Application No: P/171/21/DOC
Site Address: Rear of Inglenook Hotel 253-255 Pagham Road Pagham PO21 3QB
Description of works: Approval of details reserved by condition imposed under ref W/4001476 (P/58/19/PL) relating to Condition Nos 10 - proposed location of one fire hydrant or stored water supply, 12 - soft & hard landscaping, 14 - materials & finishes and 15 - boundary treatments.

Thank you for your internet representation made on 14th January 2022 which has been recorded as an objection with the comments as follows:

INGLENOOK PROPOSED FIRE MAIN SKETCH

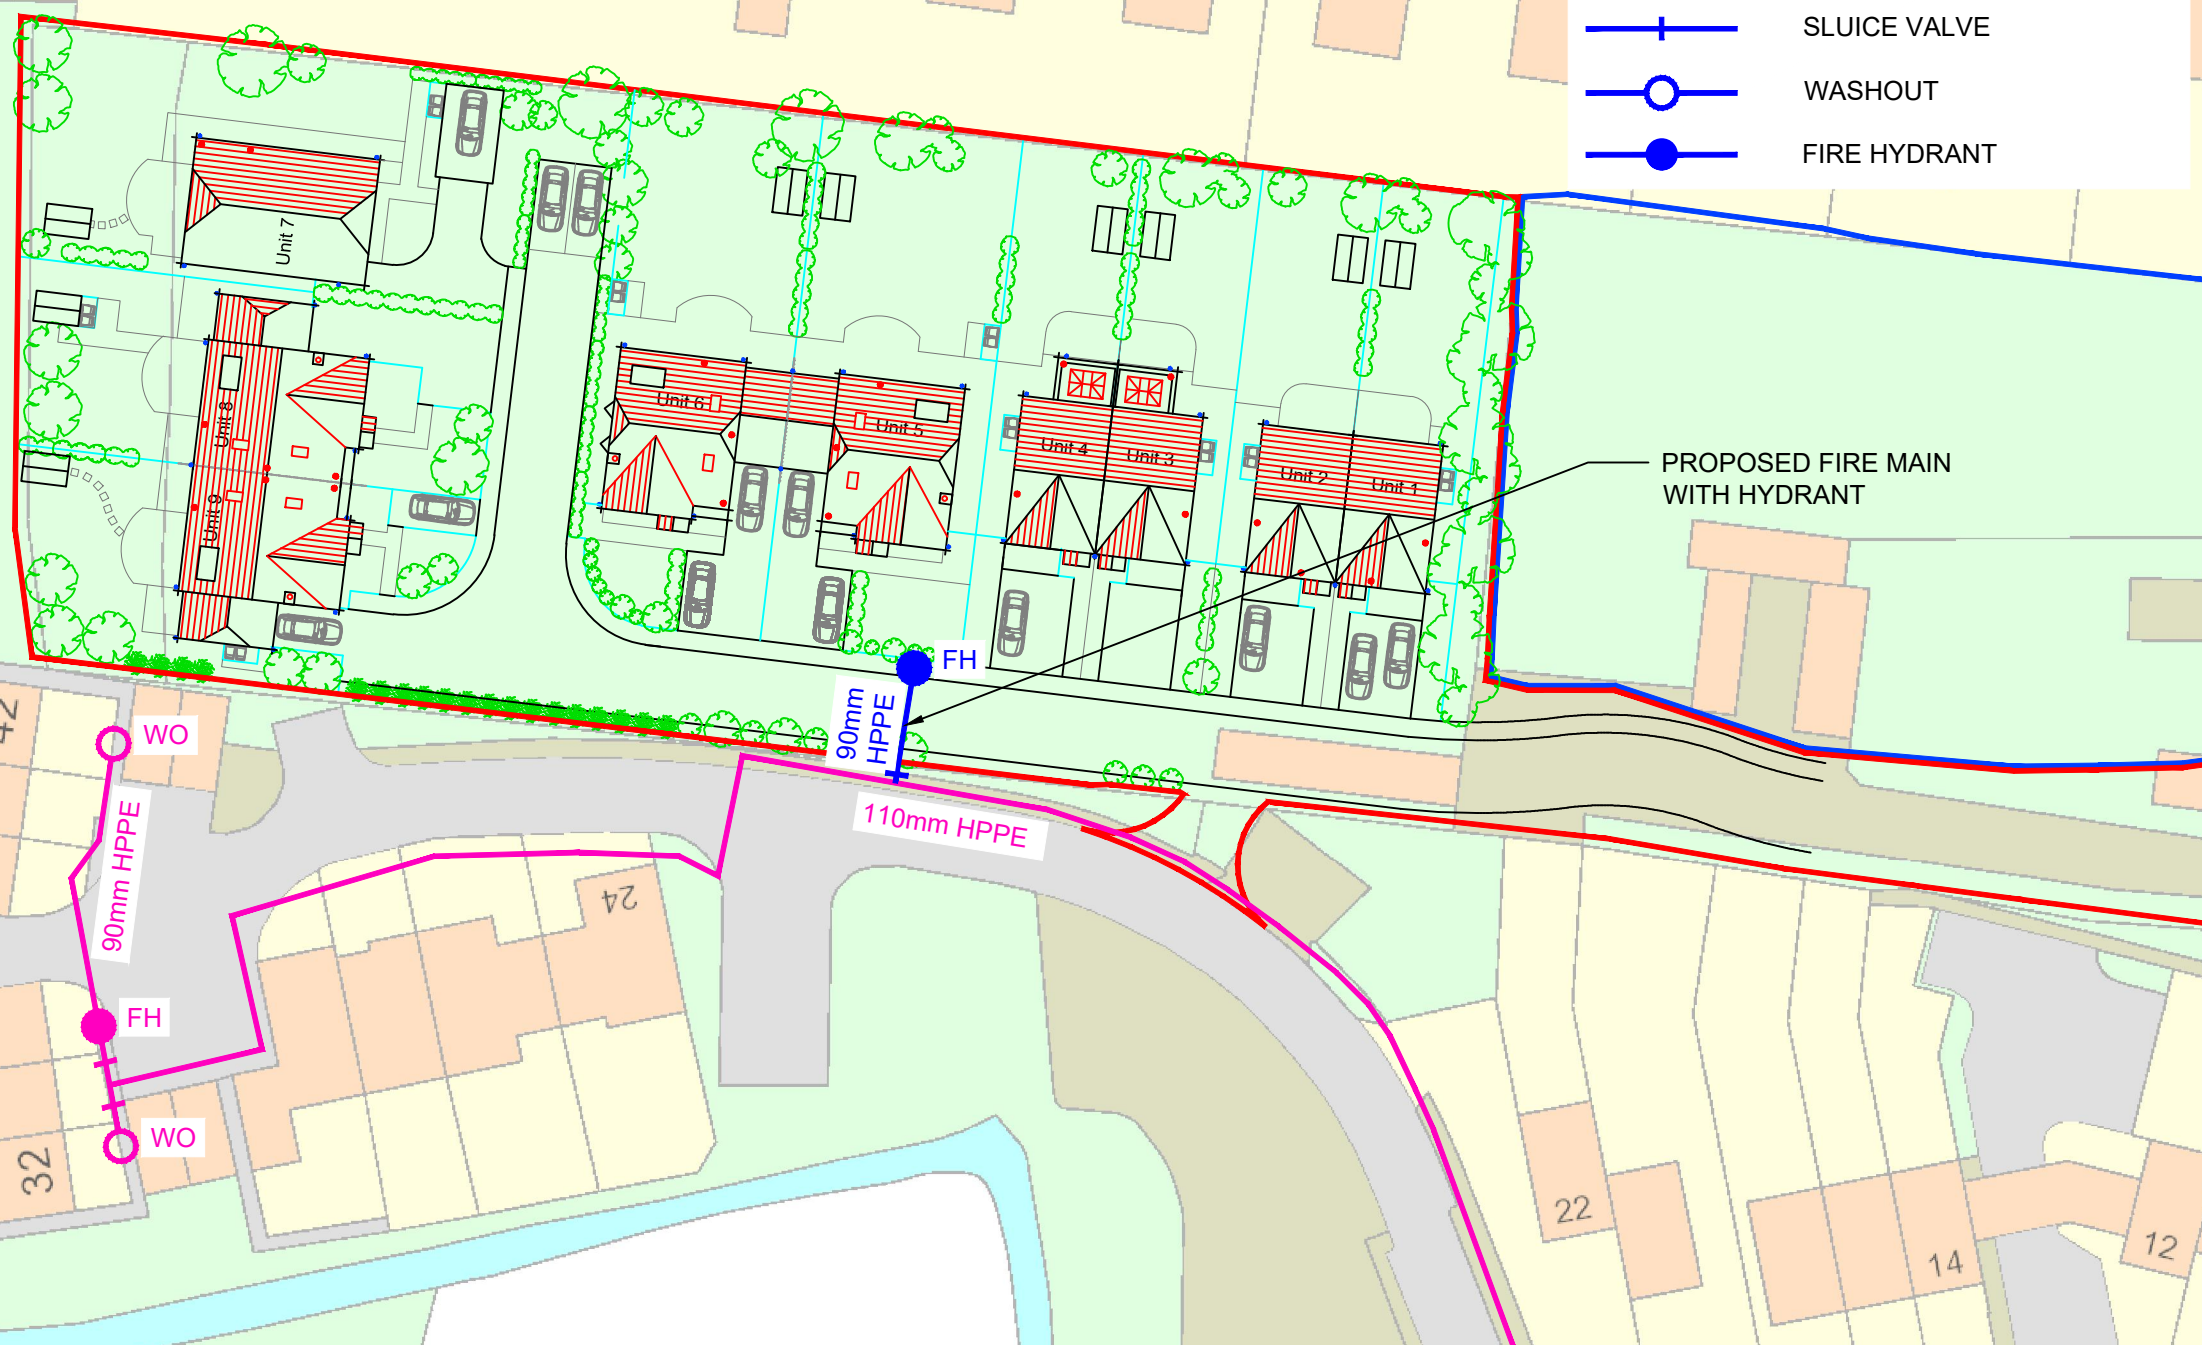
Also the proposed location for the fire hydrant connection is in our NO DIG ZONE !

Why is the developer not using HIS proposed water main for his fire hydrant??

The planning department should NOT approve a Fire Hydrant connection if permission has not been granted

The water pressure on Spinnaker View is at times very poor, as such would put lives at risk.
